DECISION DELEGATED TO DEVELOPMENT MANAGER

Application No: H13-0398-21 **Applicant:** Mr & Mrs M Moore

Proposal: Details of external materials, landscaping, boundary treatment and foul and surface water disposal (Conditions 3, 4, 5 & 6 of H13-0381-18)

Location: Rear Of 27 West Cobgate Moulton Spalding

PROJECT:	RESIDENTIAL DEVELOPMENT OF ONE DWELLING
DRAWING:	PROPOSED FLOOR PLANS & ELEVATIONS SITE LOCATION PLAN PROPOSED BLOCK PLAN
SIZE:	A1
CLIENT:	Mr & Mrs Moore
SCALE:	as labelled
DRAWN BY:	JC
SHEET:	0252/2101A

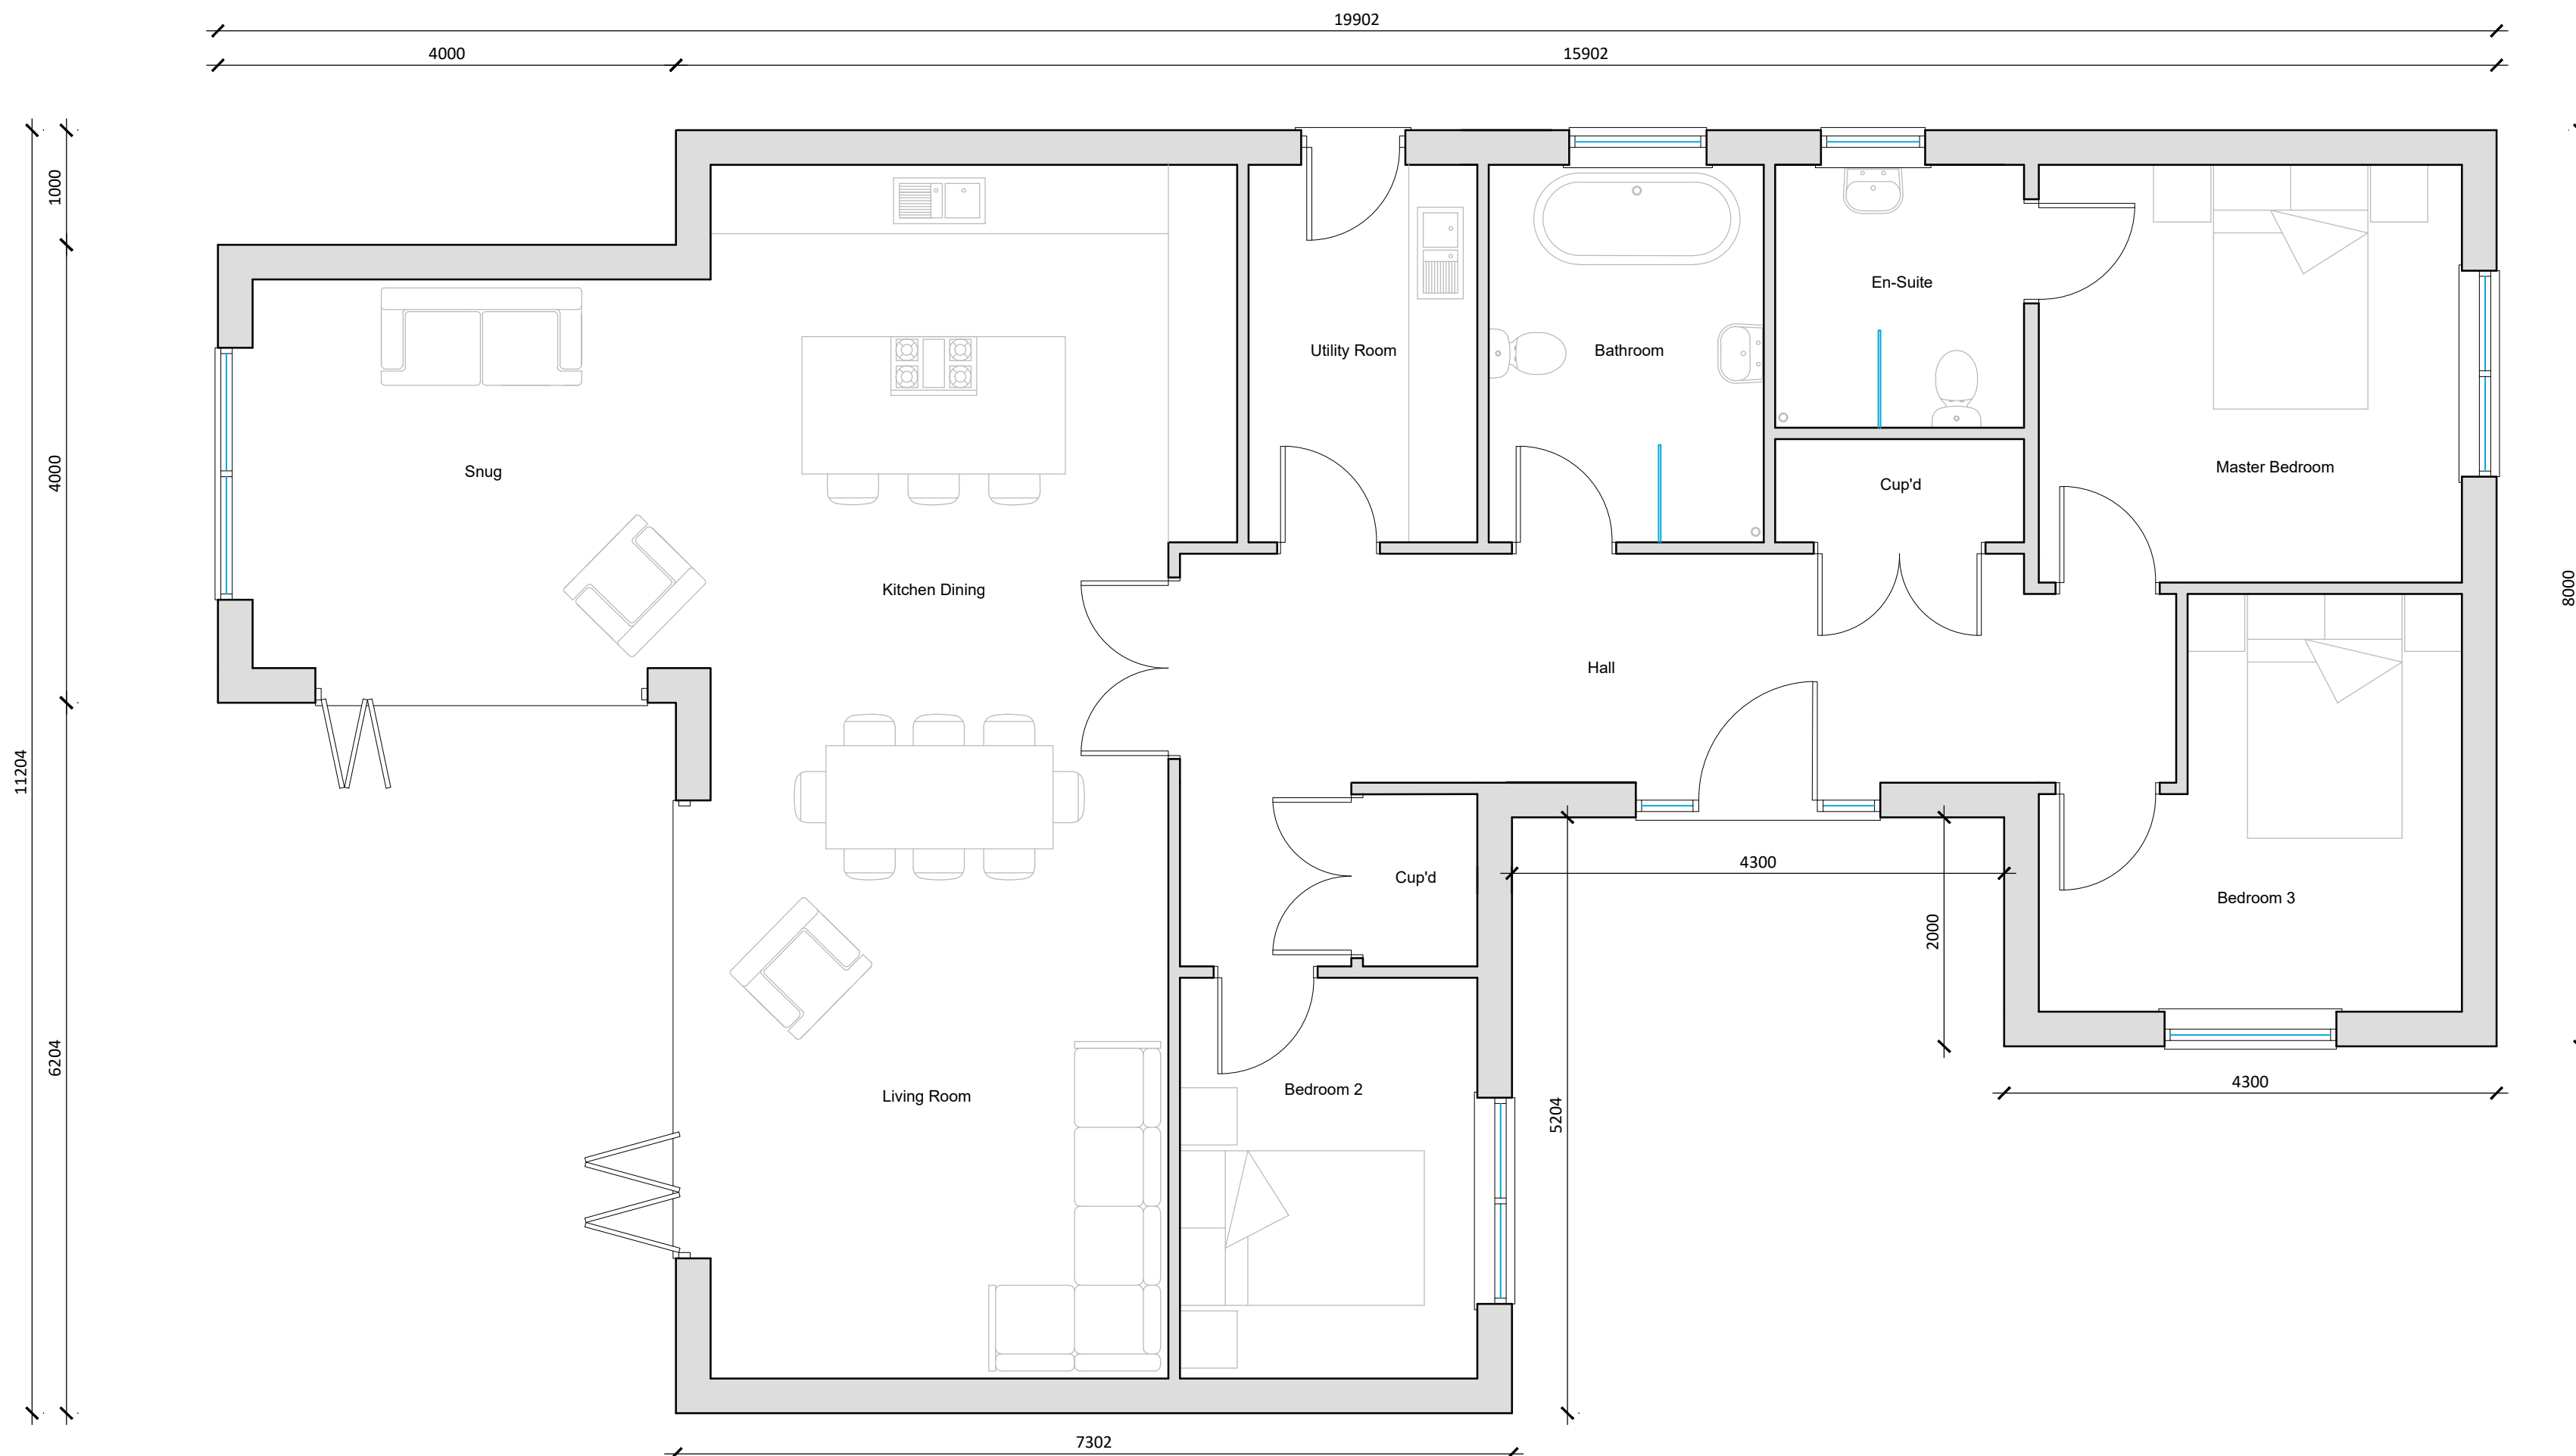
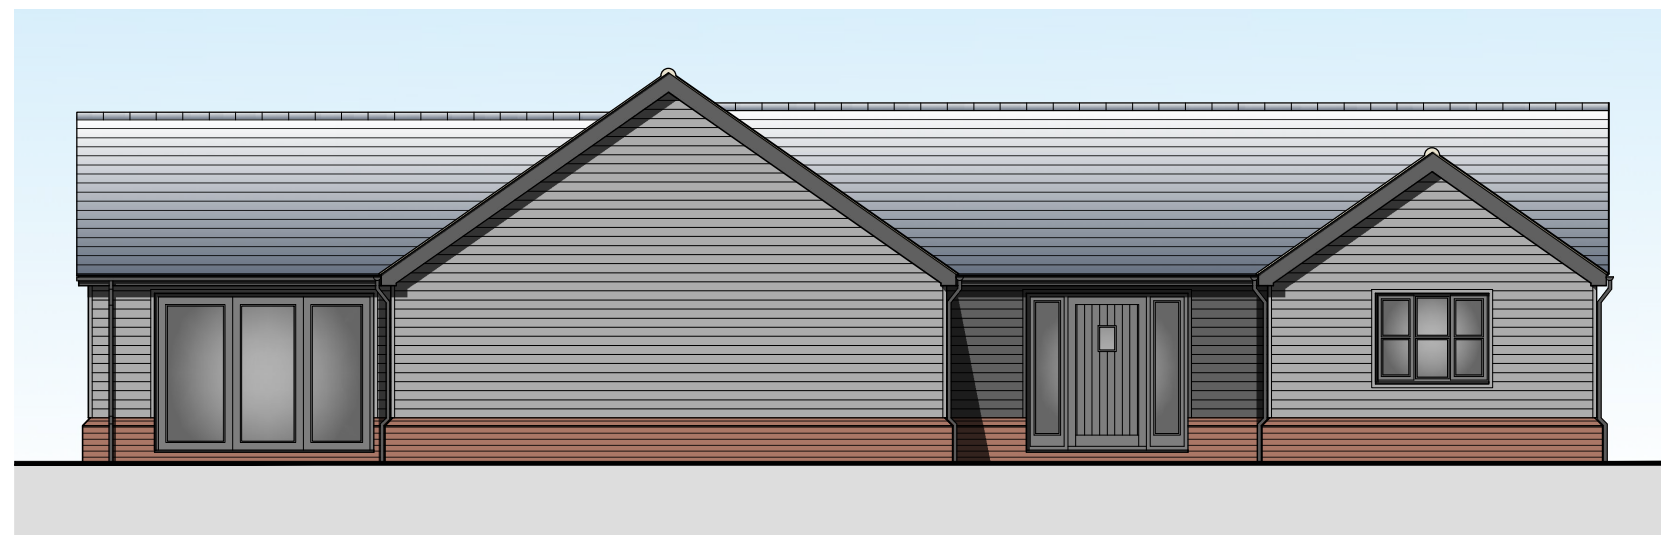
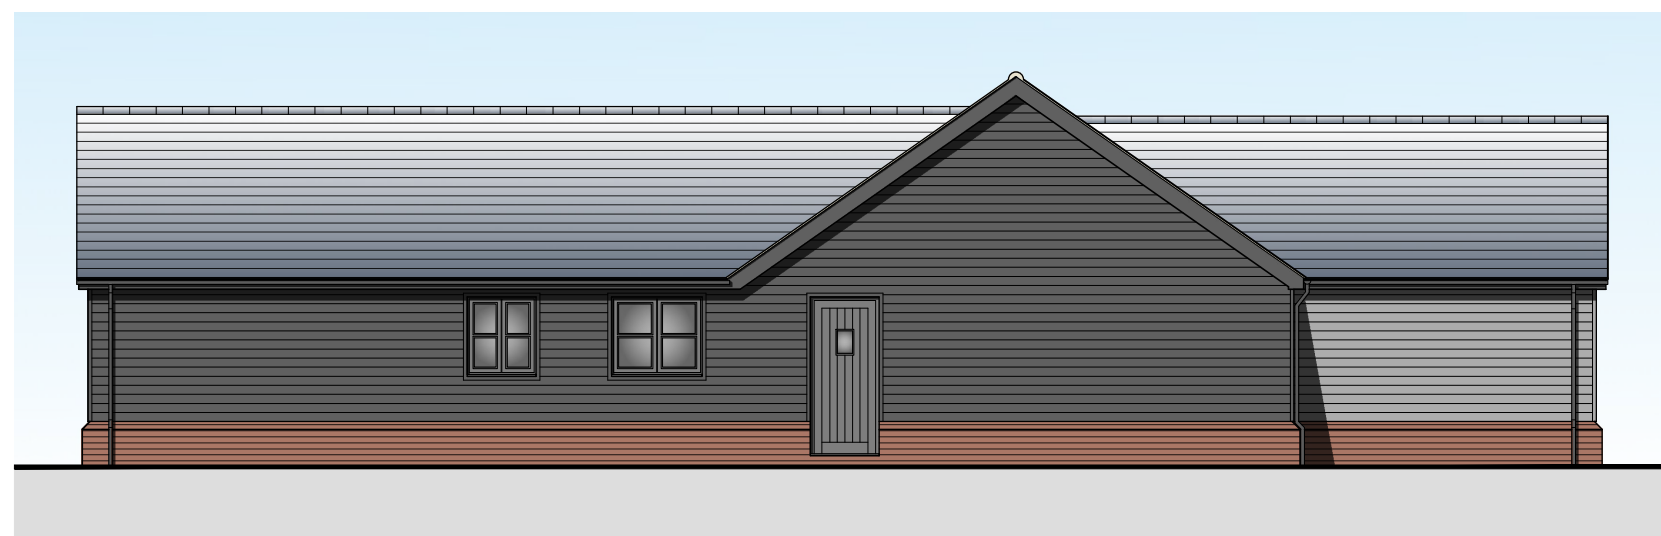
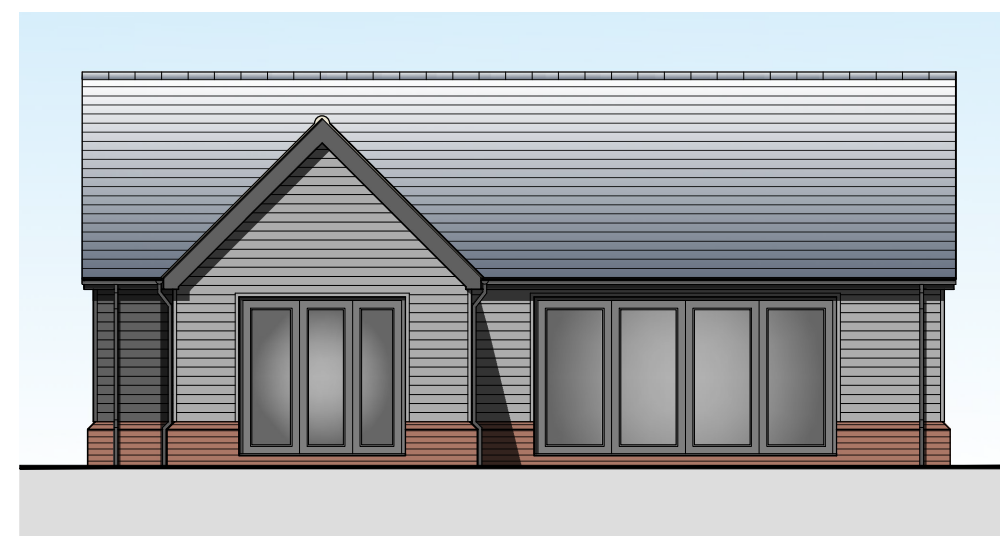
South Holland Drainage Board - Recommends that the proposed surface water drainage strategy is supported by ground investigation to determine the infiltration potential of the site and the depth to groundwater.

Condition 3 (materials schedule) - External walls would be a combination of a brickwork plinth (Wienerberger Turca Kasandra) and timber effect cladding above (Cedral - pewter and pearl). Roof tiles would be a Spanish grey slate. Driveway to be permeable block paved (Marshalls Original Tegula Priora) with patio to be constructed of flagstones. Given that the dwelling would be located to the rear of existing frontage development, and existing development is varied in terms of materials of construction, the proposed external materials are acceptable.

Condition 4 (landscaping) - The proposed landscaping is limited but in keeping with the nature of the development. In addition to the hard landscaping described above, the remainder of the curtilage would be grassed with low level planting and new native trees.

Condition 5 (boundary treatment) - The proposal is to utilise the existing 1.8m boundary fencing. Given that the dwelling is to be single storey and floor levels are not to be raised, this would be sufficient to prevent a material overlooking impact.

Condition 6 (drainage details) - The proposal is for connection to be made to the existing mains sewer for foul water disposal, which is a satisfactory arrangement. Soakways would be used for surface water disposal. There are no known ground permeability issues in this location that would preclude the use of soakaways and infiltration is the preferred method for surface water disposal in accordance with the drainage hierarchy.

Taking the above into account, it is considered that Conditions 3, 4, 5 & 6 of H13-0381-18 can be discharged.
